REFUSAL OF PLANNING PERMISSION

APPLICATION NO. 2018/0919

Proposal First floor rear extension over kitchen and 3 storey rear extension.

At 11A Park Grove, Barnsley, S70 1PY

PLANS & ELEVATIONS

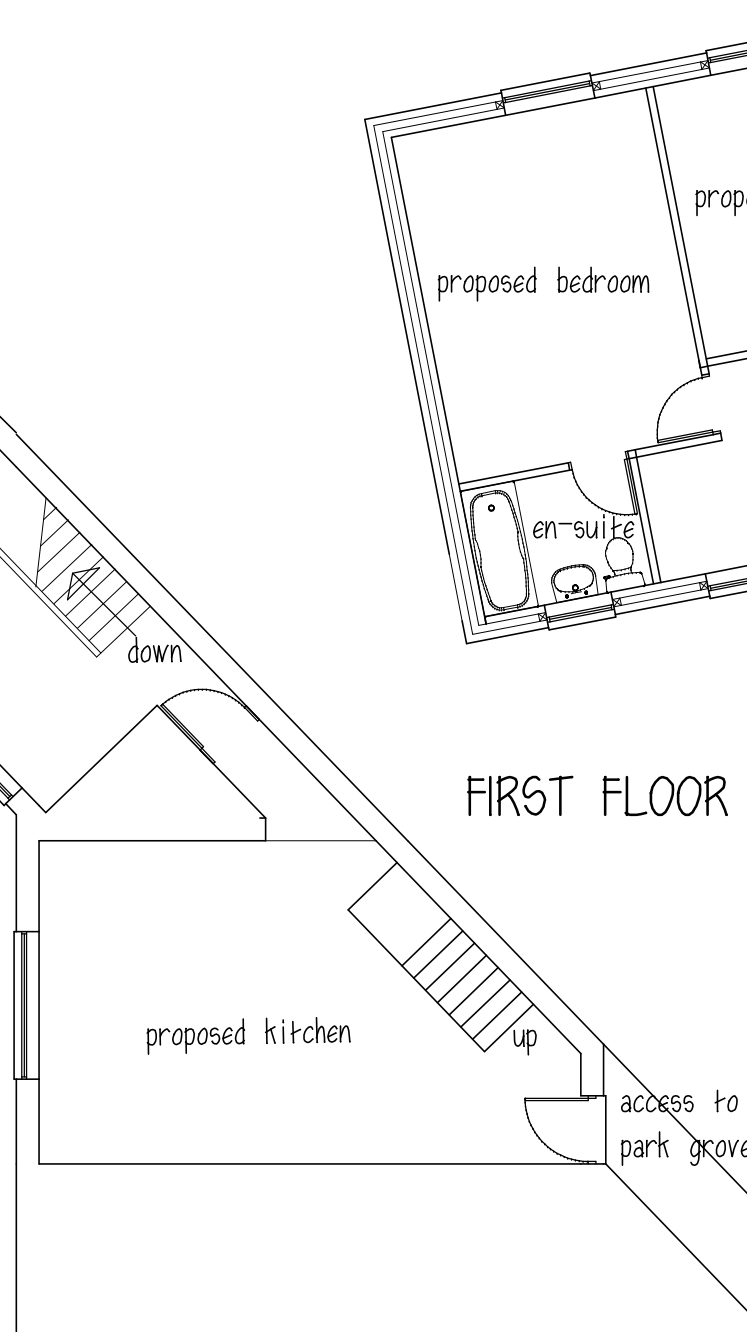
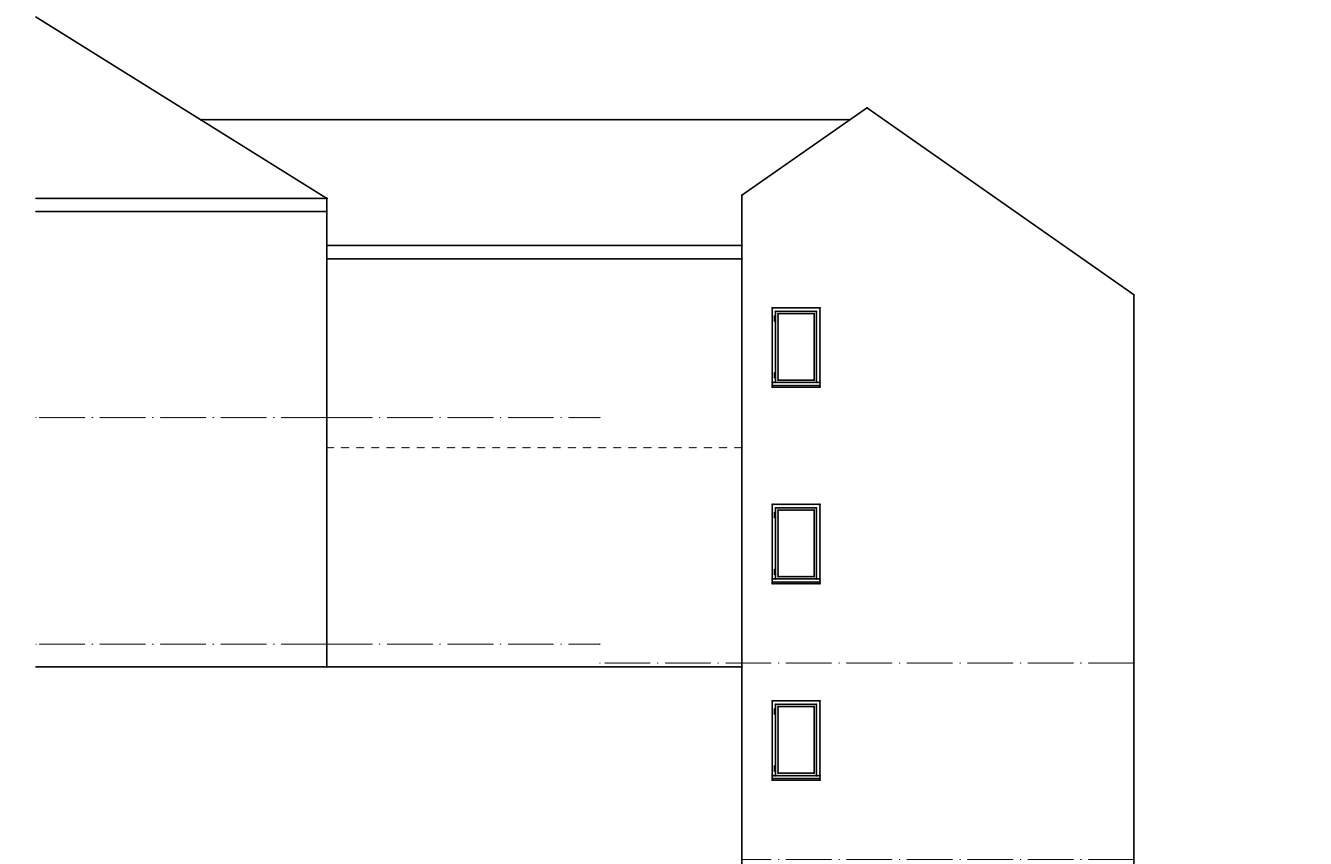
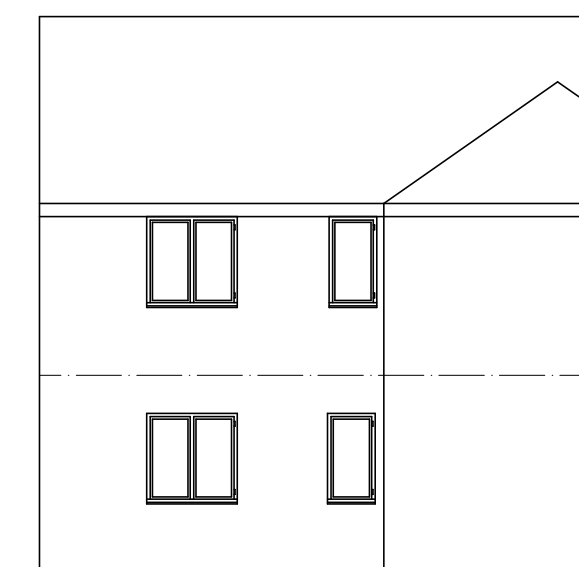
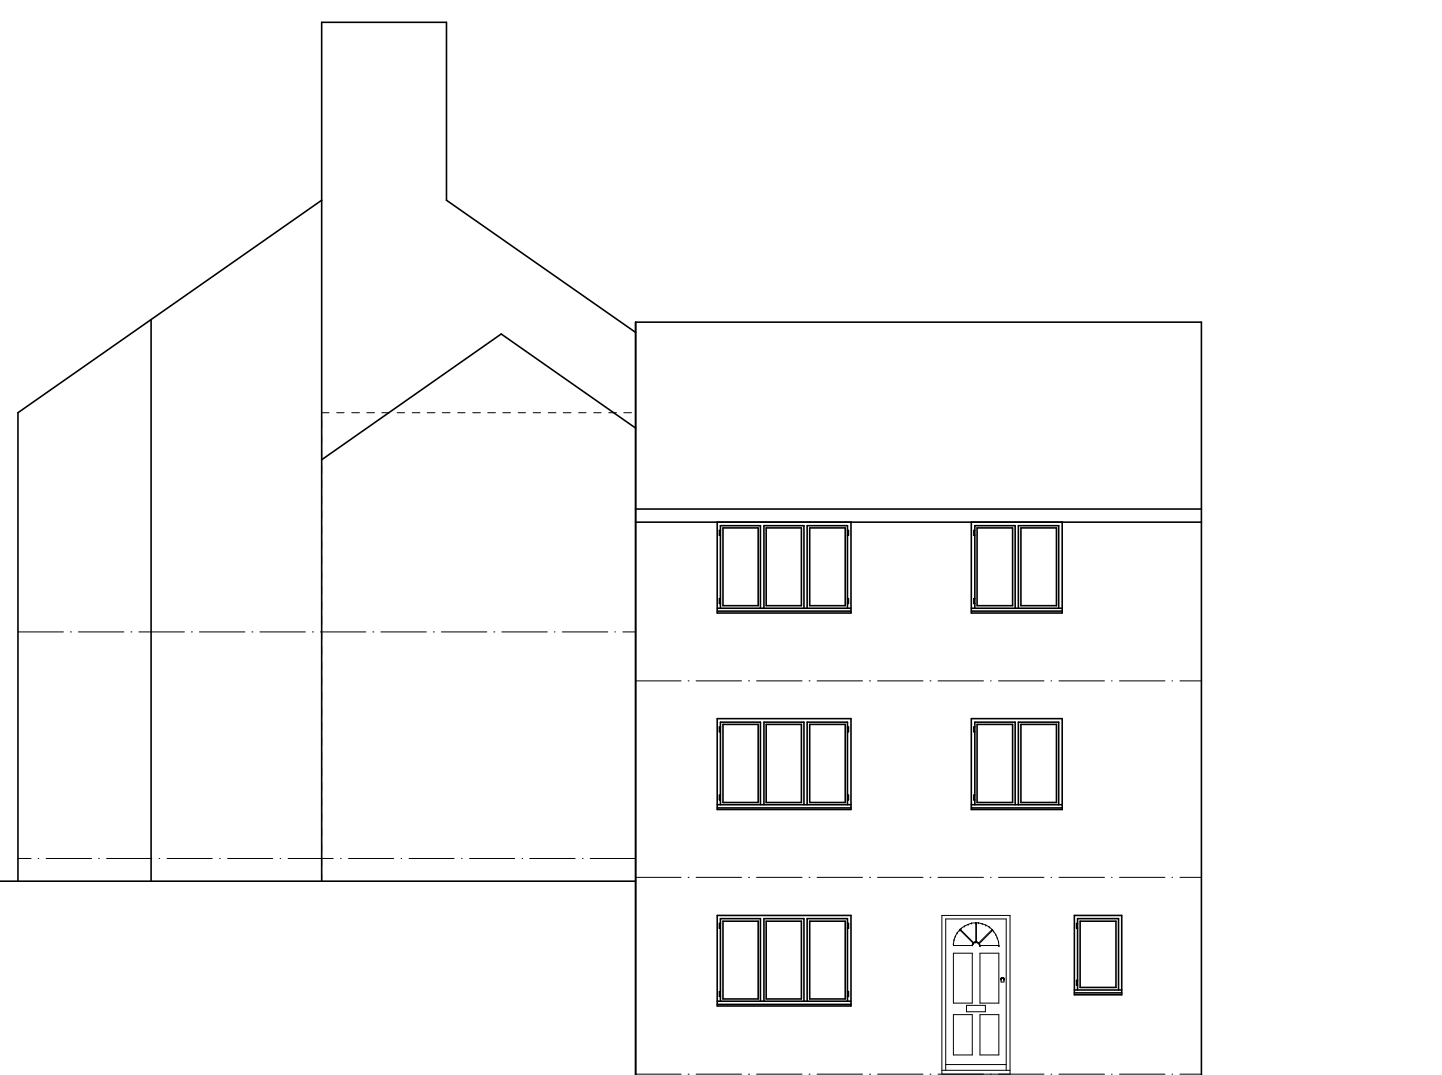
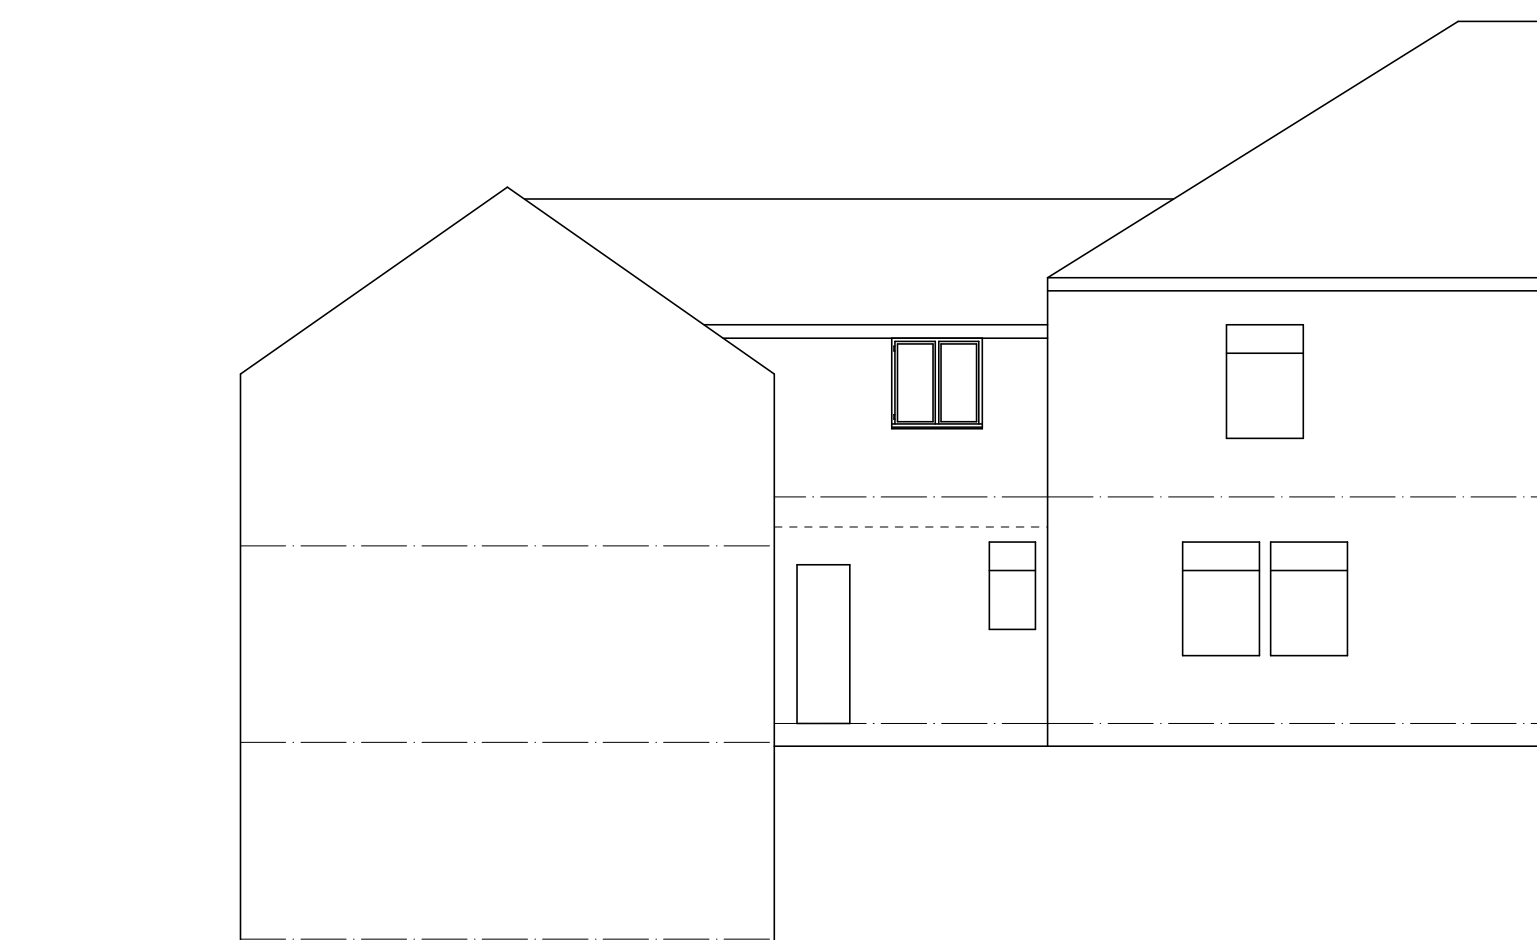
- 1 In the opinion of the Local Planning Authority, the proposed first floor and three storey rear extensions would be, due to their size, position and orientation, materially detrimental to the amenities of the occupants of the adjoining dwellings by reason of their overbearing and overshadowing impact, contrary to Core Strategy Policy CSP 29 and the Council's Supplementary Planning Document - House Extensions.

- 2 In the opinion of the Local Planning Authority the addition of first floor and three storey rear extensions would form an incongruous feature by virtue of their design. The design of the extension would not present itself as a subordinate or sympathetic addition. Further to this the increase to the properties mass would further unsettle the relationship to neighbouring ones which is not in-keeping with the overall appearance of the locality, this would fail to improve the character and quality of the streetscene as a whole. Overall this is considered to be contrary to the requirements of policy CSP 29 and the Supplementary Planning Document - House Extensions.
